Road Safety Audit – A29 Shripney Road

Stage:	1
Location:	A29 Shripney Road, Shripney, West Sussex
Site:	Proposed right turn lane and new site access (Audit of proposed modifications to informal pedestrian crossings)
ATSS Ref:	200108
Client Ref:	1845
Date:	5 February 2020

- 1.2 Further to discussions with Highway Officers, the scheme has been modified, and a further Stage 1 audit has been commissioned, to consider the changed proposals. These include:

DATE:	DRAWN BY:	CHECKED:
21/10/19	BL	DT

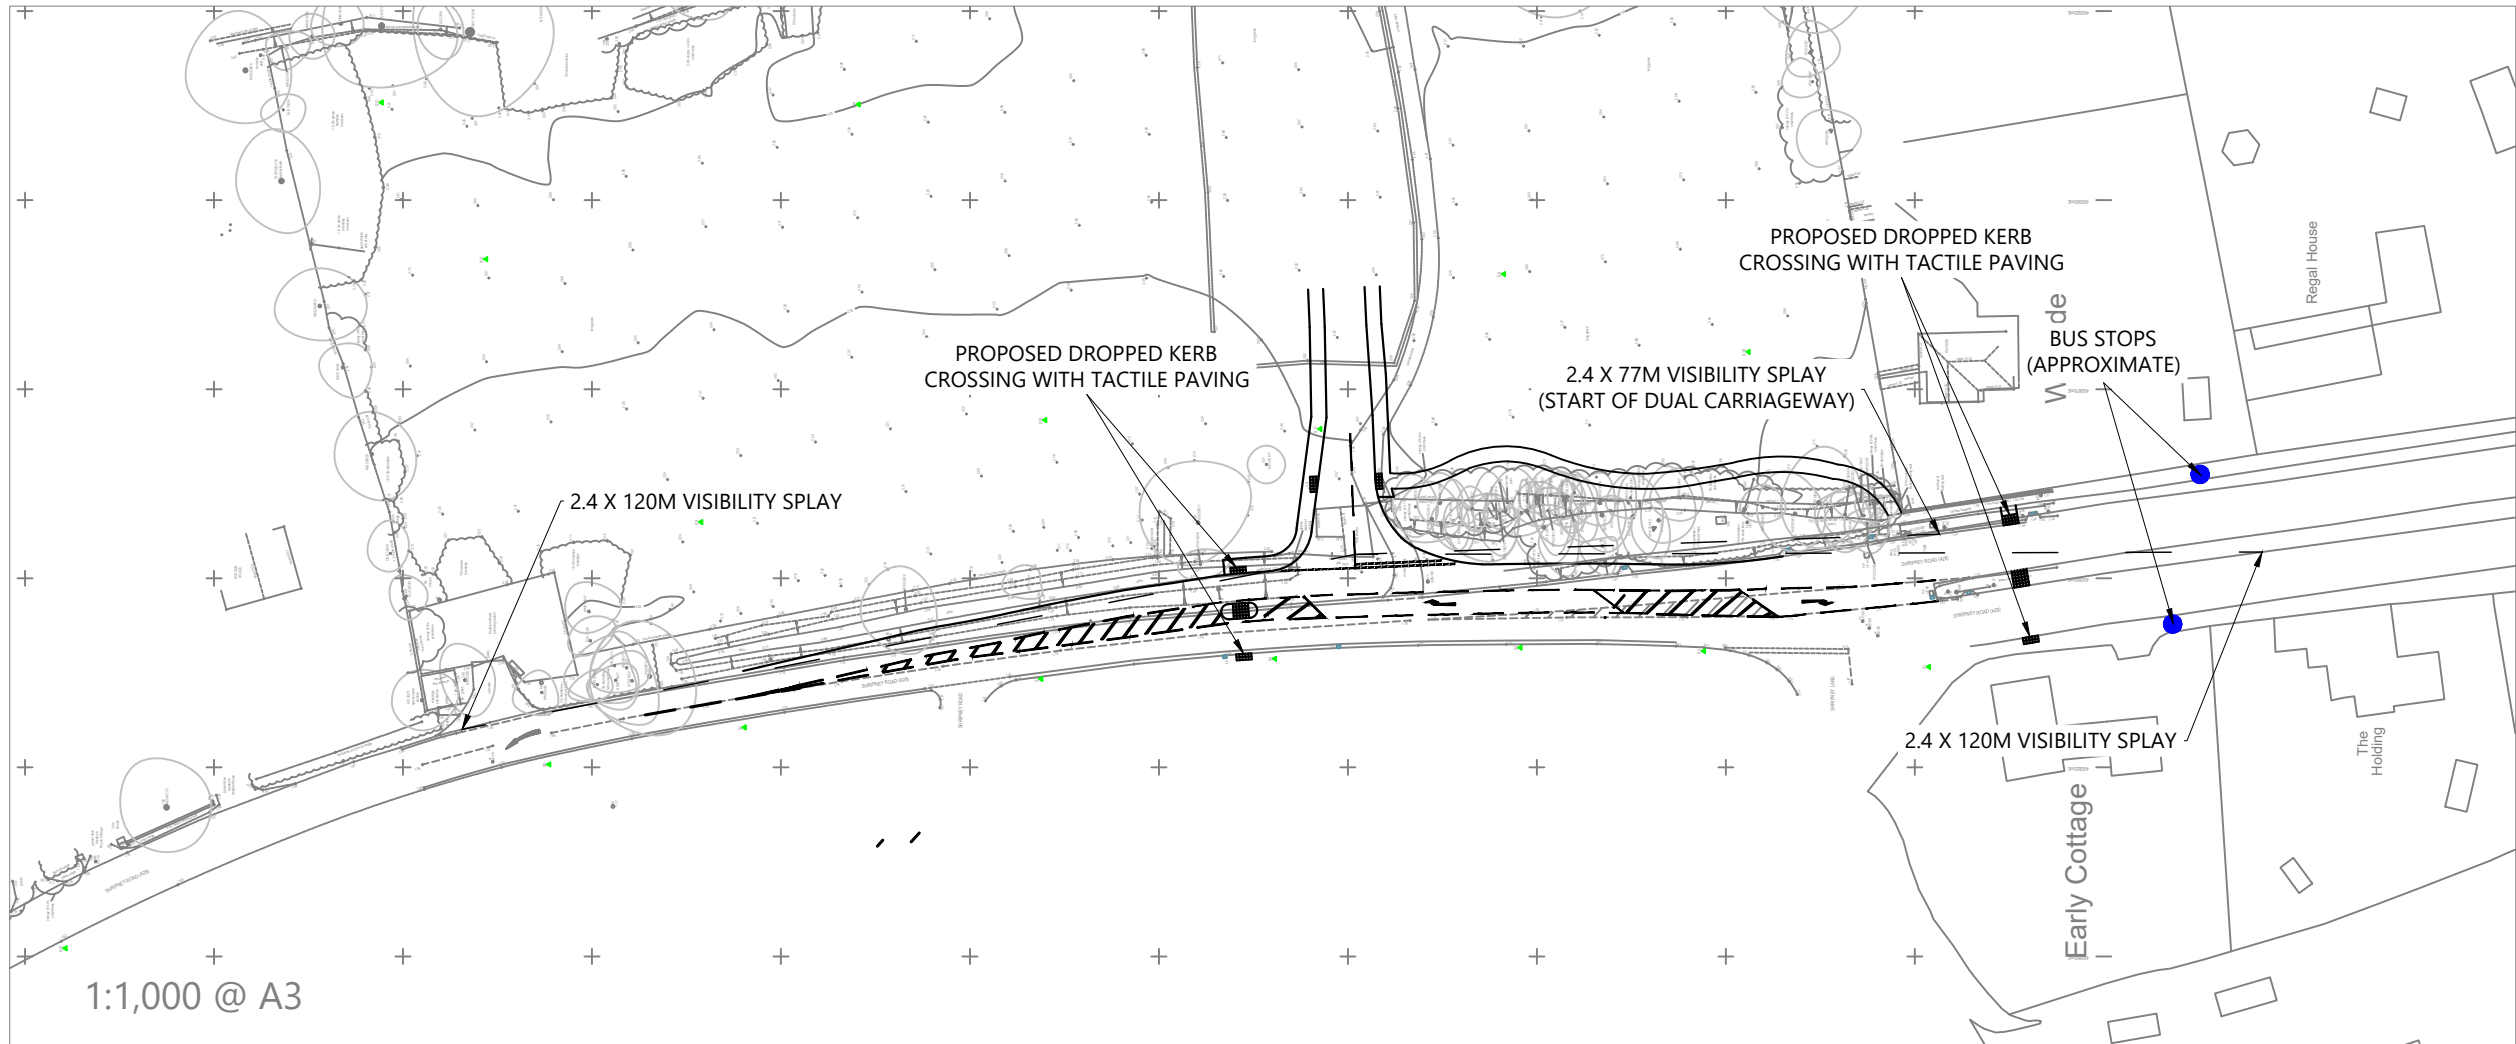
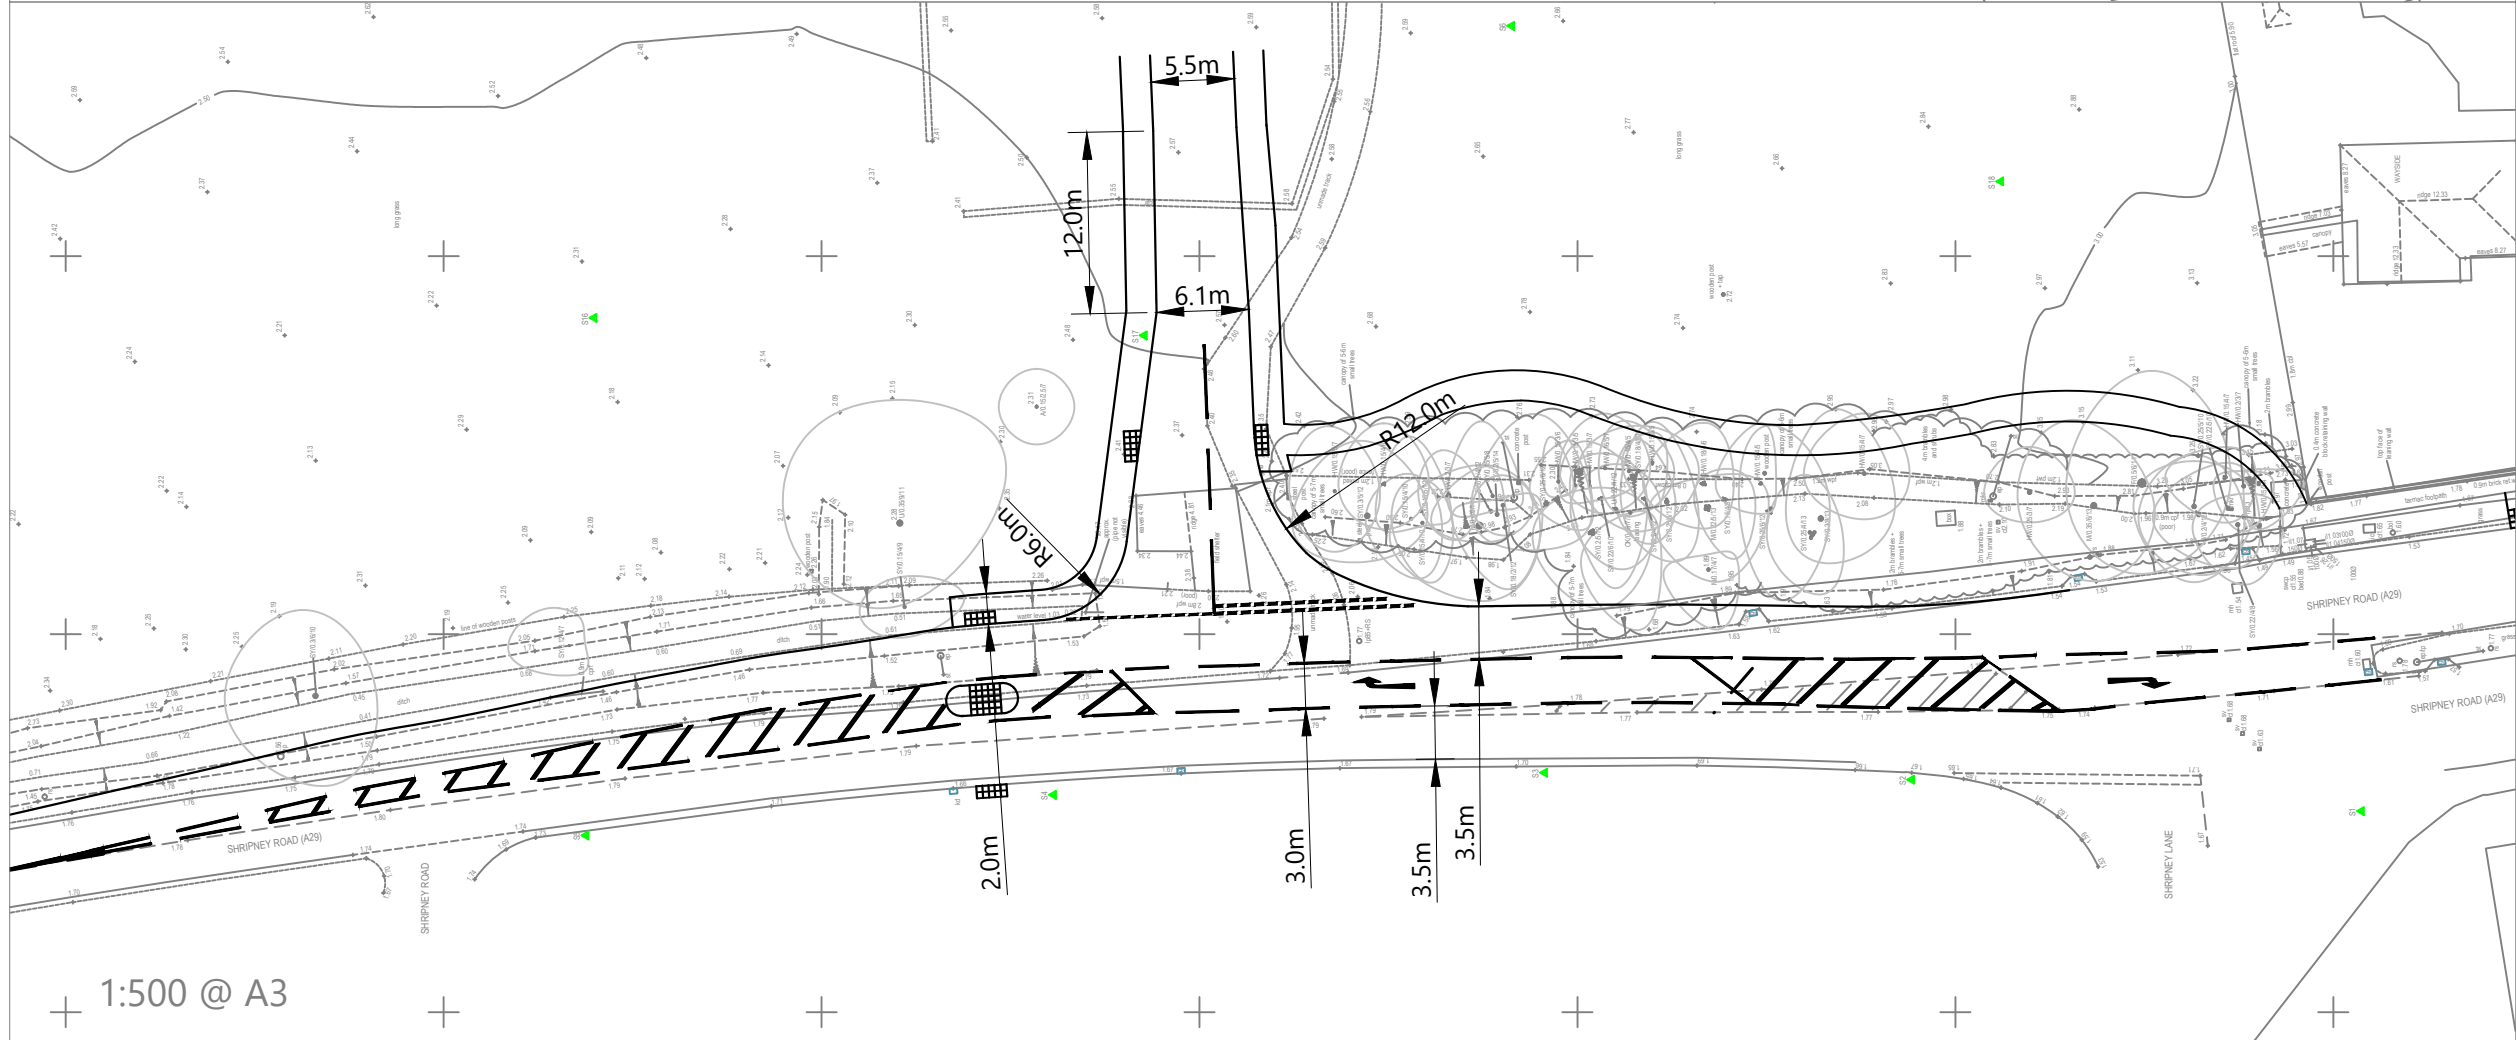
The existing informal pedestrian crossing at this location is proposed to be upgraded so that it is realigned and incorporates an area of tactile paving. The boundary wall and fence of an adjacent residential property inhibits visibility to the proposed crossing of those approaching from the south along the dual carriageway. This increases the likelihood of pedestrian/vehicle conflict particularly for vulnerable groups such as older users and those with mobility and visual impairment. The high approaching speeds observed on site together with the lack of any deflection for vehicles turning in to Shripney Lane will increase the risk of such collisions (see photo 2.1).

The existing boundary fence and wall inhibits visibility to the proposed pedestrian crossing point and increases the risk of vehicle/pedestrian conflict. Evidence on site also indicates that drivers turning left out of Shripney Lane mount the kerb as their attention is drawn to vehicles approaching from the south (often at speed), along the dual carriageway (see photo 2.2).

The existing road layout at the A29/Shripney Lane junction and the provision of the new central refuge island means that those approaching from the south (often at speed and overtaking) will be squeezing past this point while pedestrians are waiting to cross increasing the likelihood of vehicle/pedestrian conflicts. Site observations also indicate vehicle wheel tracking very close to the existing kerblines (see photo 2.3).

Northbound vehicles approach the site at speed, with some using the offside lane to overtake. A lack of judgement by an overtaking driver, who leaves it too late to pull to the left, is at risk of colliding with the proposed island

The new crossing point is proposed to be installed within an area of existing foliage. If this is not removed to ensure sightlines to and from the new crossing are maintained there is a high risk of pedestrians stepping into the carriageway and being struck by approaching vehicles (see photo 2.5).

Recommendation – Realign and build out the existing kerblines at this corner to increase visibility to and from the crossing. The resulting increased deflection together with the reduced entry radius at this corner will influence entry vehicle speeds and minimise the risk of conflict with those crossing.

Recommendation – Increase visibility at this point by building the kerb further out into the carriageway. If the existing kerblines were realigned on both sides of the junction and the refuge island was omitted visibility would be improved on both sides of this junction (see problem 2.1).

Recommendation – Install measures along the northbound approach of the dual carriageway in advance of the Shripney Lane junction to alter driver behaviour at this point. This may include reducing the northbound carriageway to a single lane of traffic (which will also improve visibility which has been raised as a problem in section 2.1), by the use of extra hatching on the approach, and possibly a local build out of the central reservation, appropriately signed; enhancing the existing signage; and reducing the existing speed limit. Also reinstate the existing edge of carriageway markings to guide vehicles away from the edge of the carriageway.

Recommendation – Install measures along the northbound approach of the dual carriageway in advance of the Shripney Lane junction to alter driver behaviour at this point. This may include reducing the northbound carriageway to a single lane of traffic by the use of extra hatching on the approach, and possibly a local build out of the central reservation, appropriately signed; enhancing the existing signage; and reducing the existing speed limit.

Recommendation – Remove the existing vegetation and establish methods to permanently maintain required sightlines.
